Babergh District Council and Mid Suffolk District Council (20041302)

Deadline 8 submission for Bramford to Twinstead (EN020002)

The purpose of this submission is to present the councils' response in respect of the following items due at deadline 8:

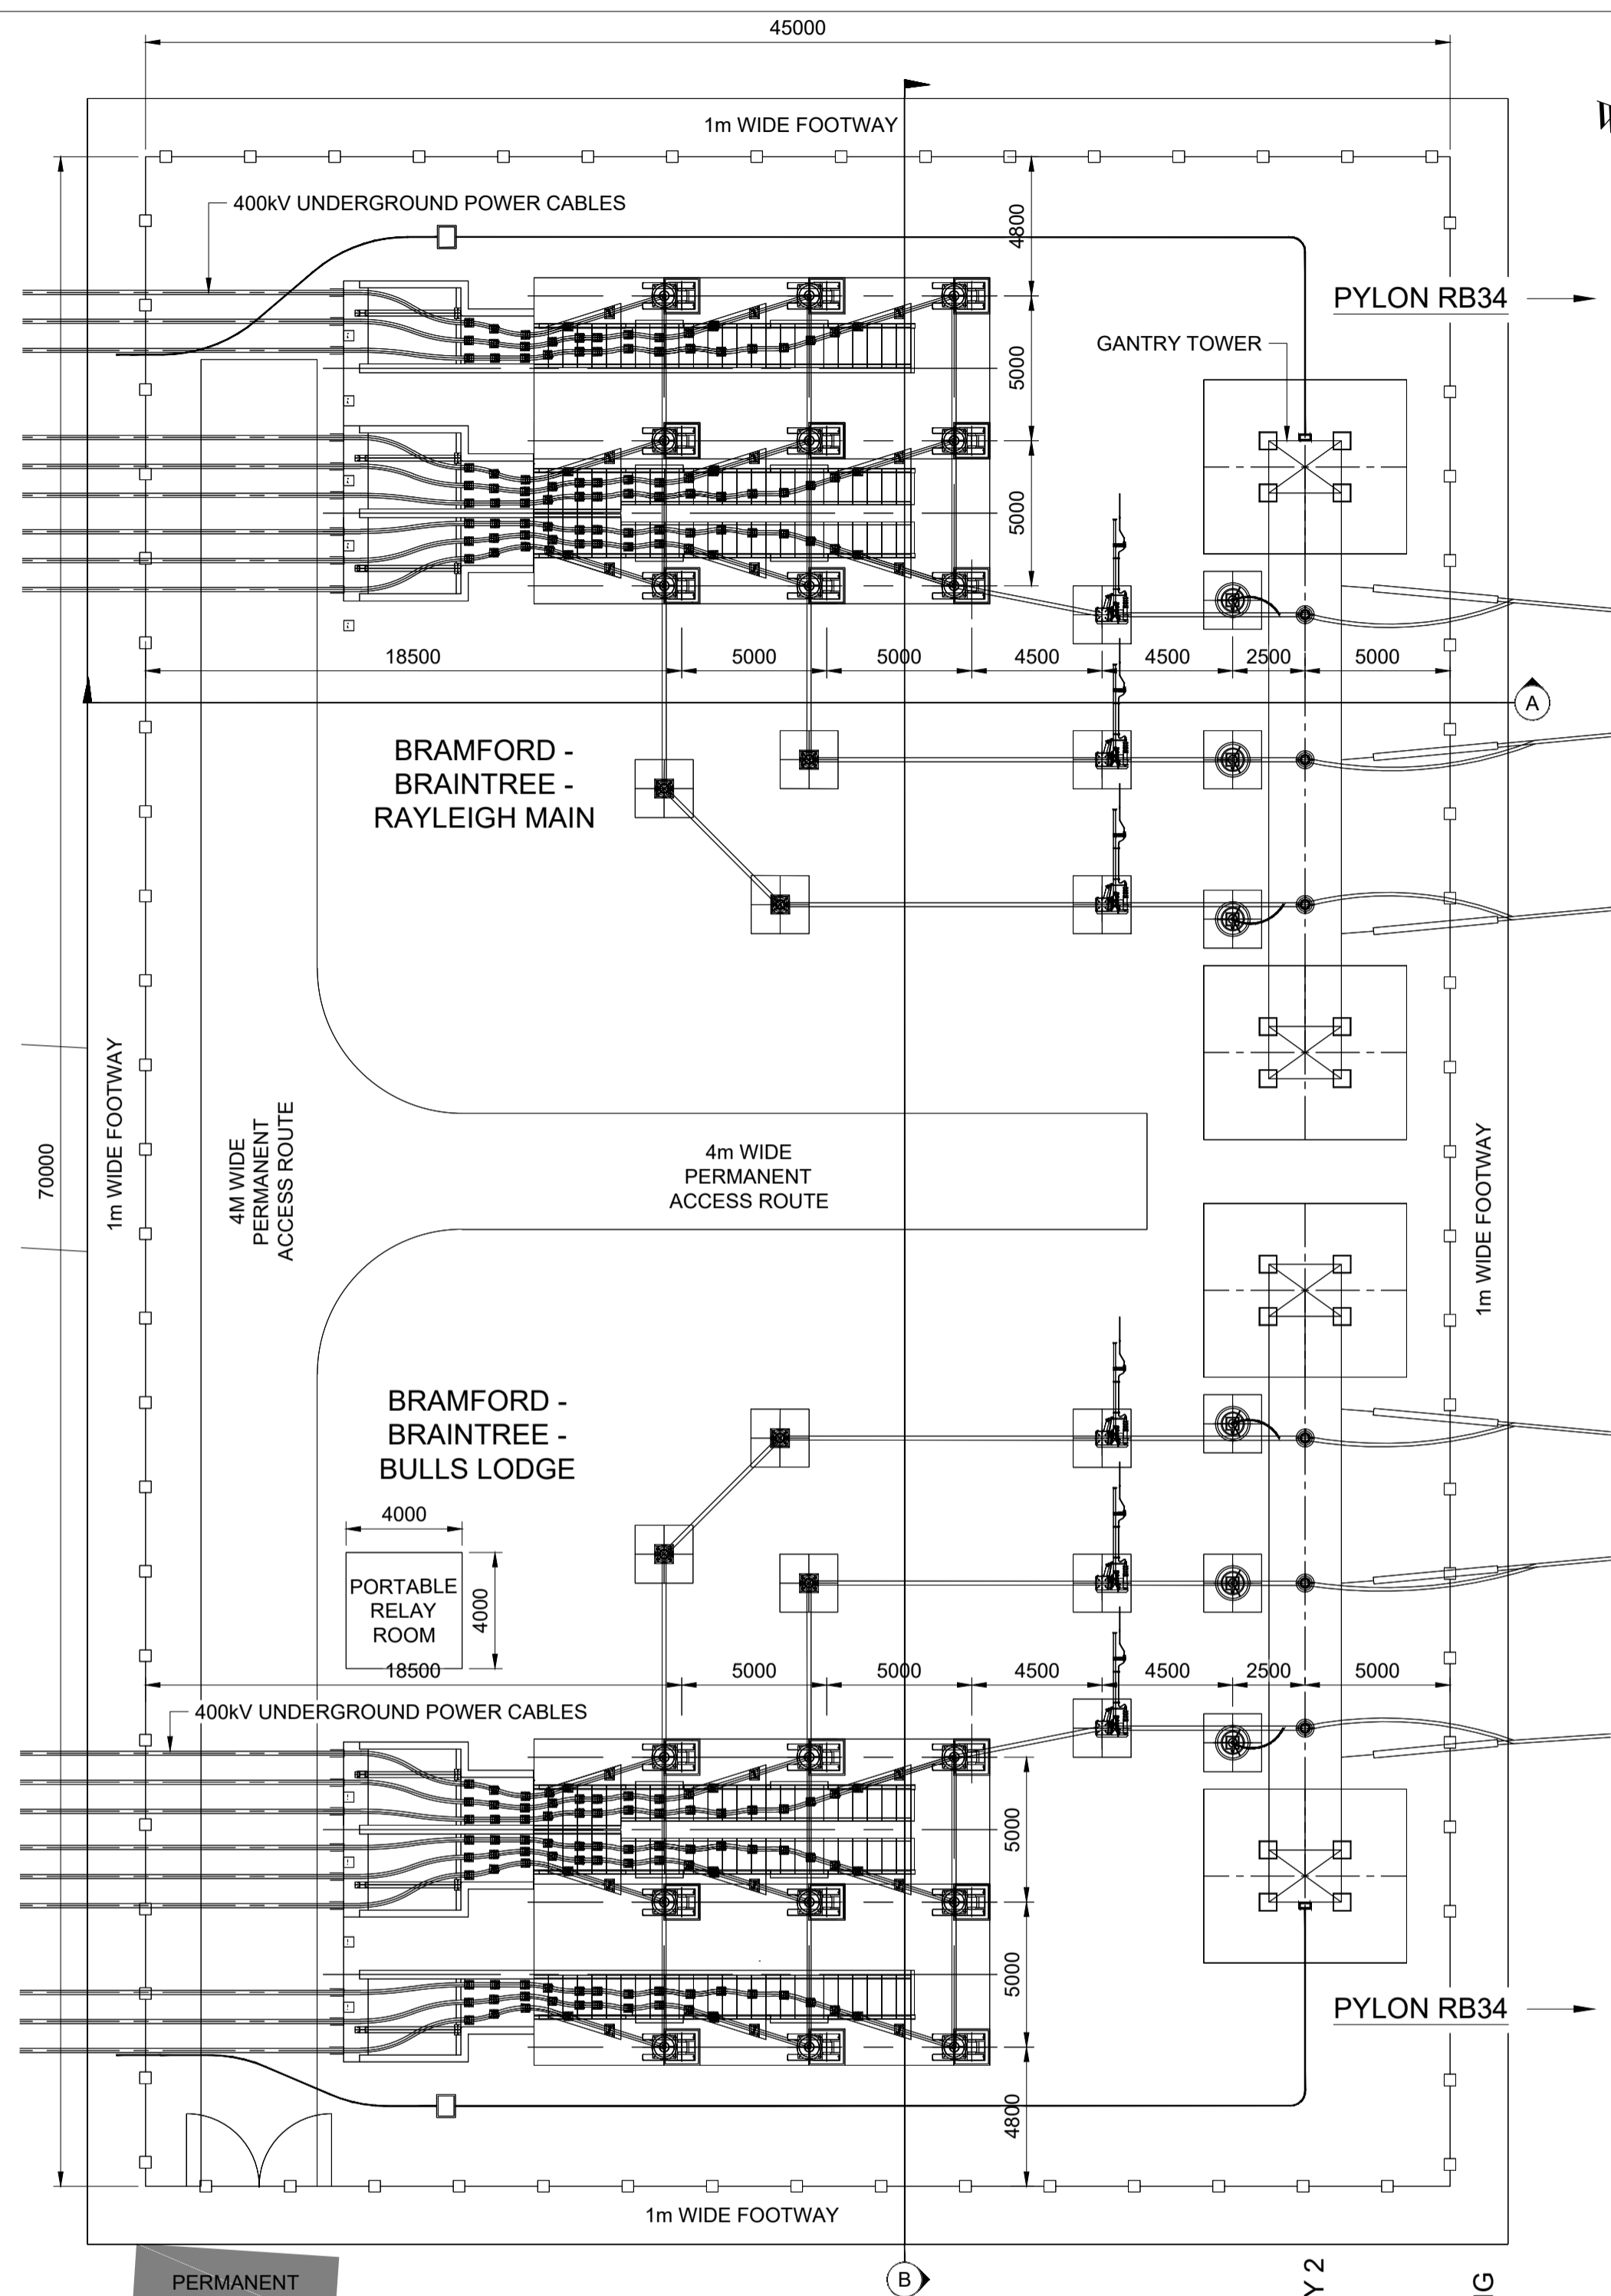
2.3.3 Babergh and Mid Suffolk District Councils note that they still have concerns and comments in respect to the Dedham Vale East cable sealing end (CSE) compound and Stour Valley East CSE compound. The Applicant responded to specific points on these in the Applicant’s Comments on Other Submissions Received at Deadline 5 [REP6-045] in Section 2.4 and Table 7.1 respectively. The Applicant updated Requirement 9 of the draft DCO [REP6-003] at Deadline 6 to confirm that the reinstatement planting plan submitted to the relevant planning authority must include a landscape plan for each CSE compound, which will show the proposed hard and soft landscaping and proposed finishes for hard landscape features in response to the Councils on this matter.

Response: BMSDC retains concerns that, as the LEMP is not an outline document, the councils’ actual control of the extent of planting will be minimal post DCO, at the point that the landscape plans are submitted for approval.
